From: Fiona Fitzgerald
Sent: 11 December 2018 12:13
To: Planning.Responses
Cc: Simon Davis
Subject: P/108/18/PL

Drawing Number:
4183-220
Revision:
-

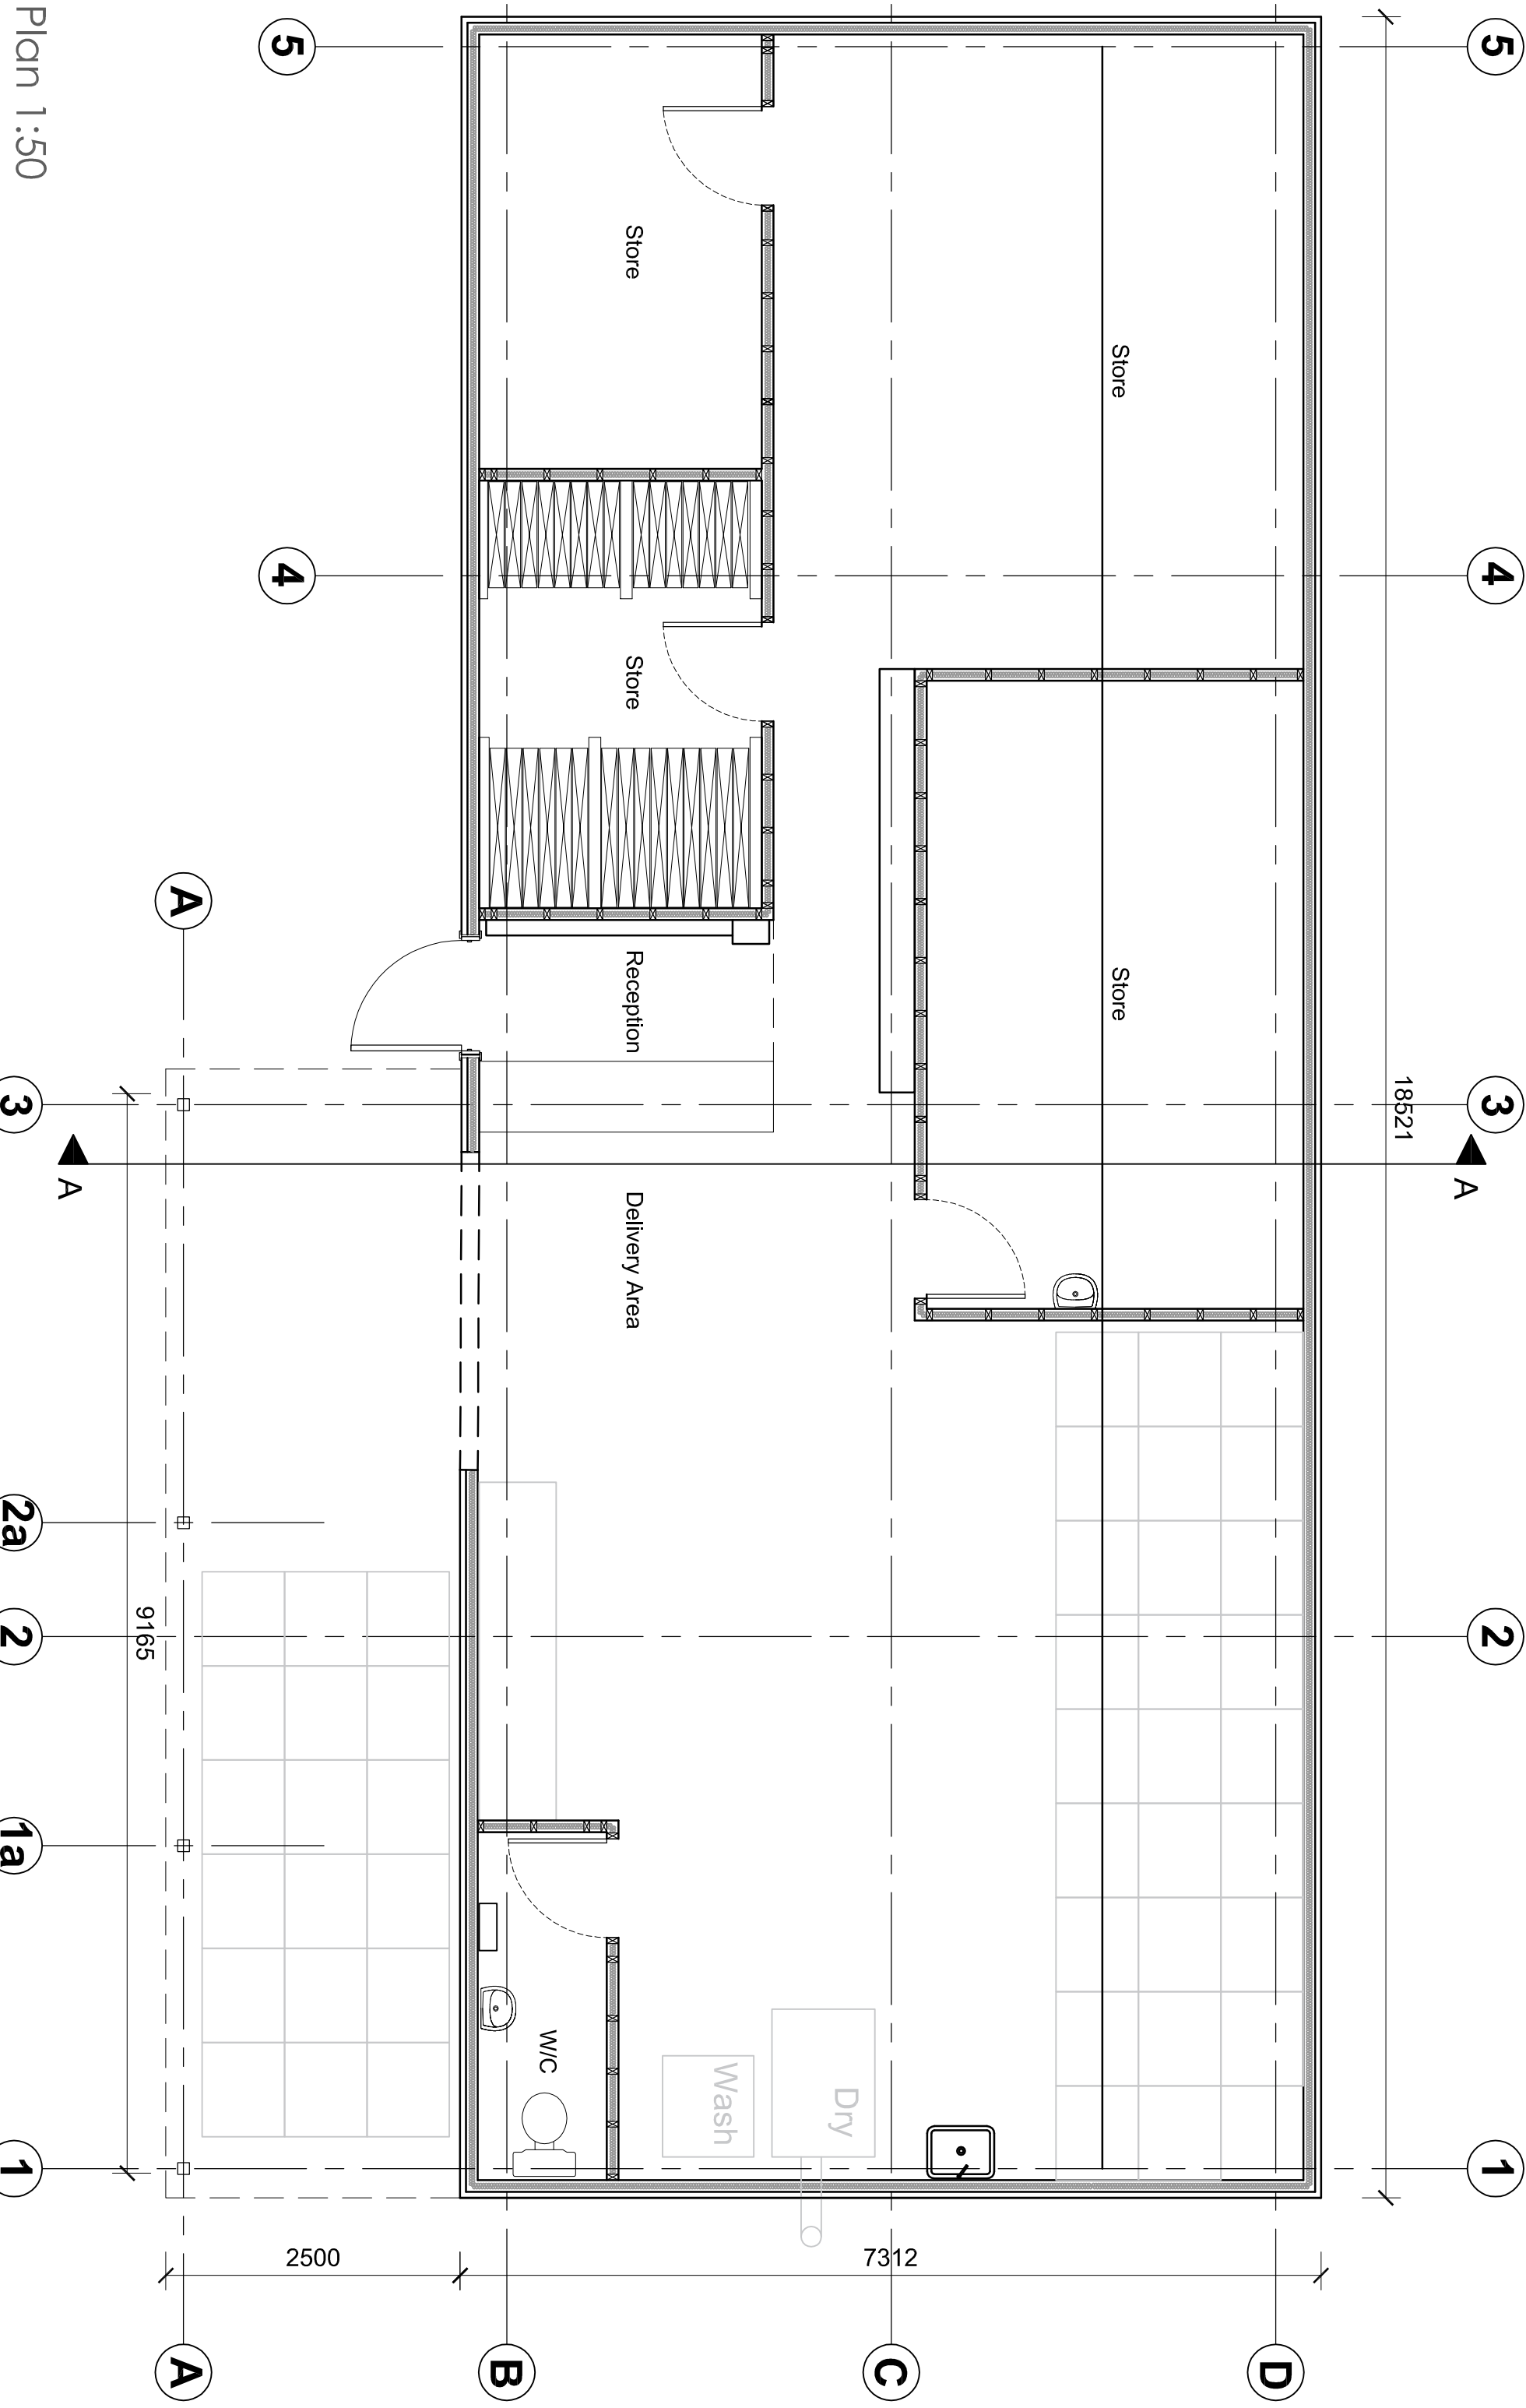
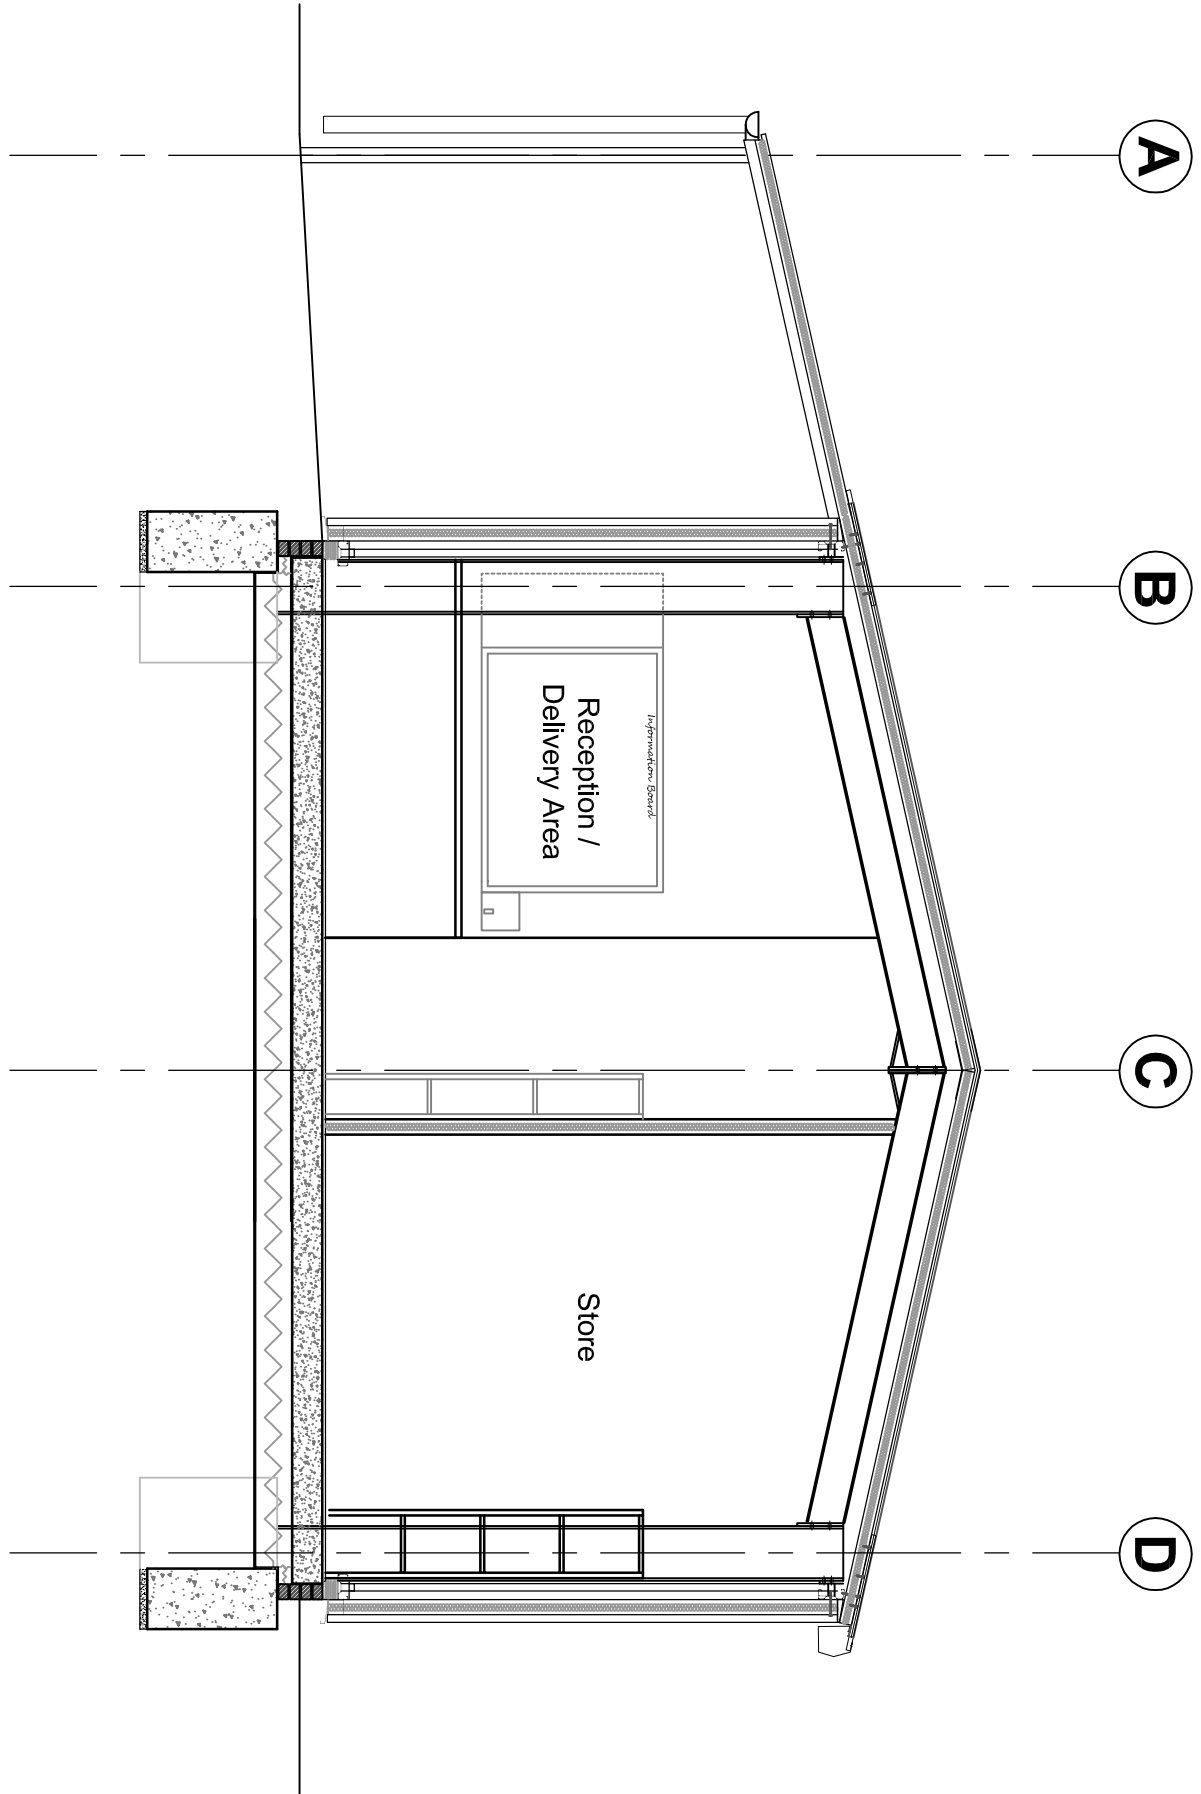
1. If there are any planned hours of use of the new building? I am aware that historically we have had a number of noise complaints from local residents and am keen to understand whether there are any noise implications from the use of the building.
2. Is there any intention of keeping food in the building? I am referring to food for the use of the site, not staff sandwiches! Should food for the site be stored in the building, there would be an issue with the sanitary facilities as there is only one door leading from the toilet and no lobby.
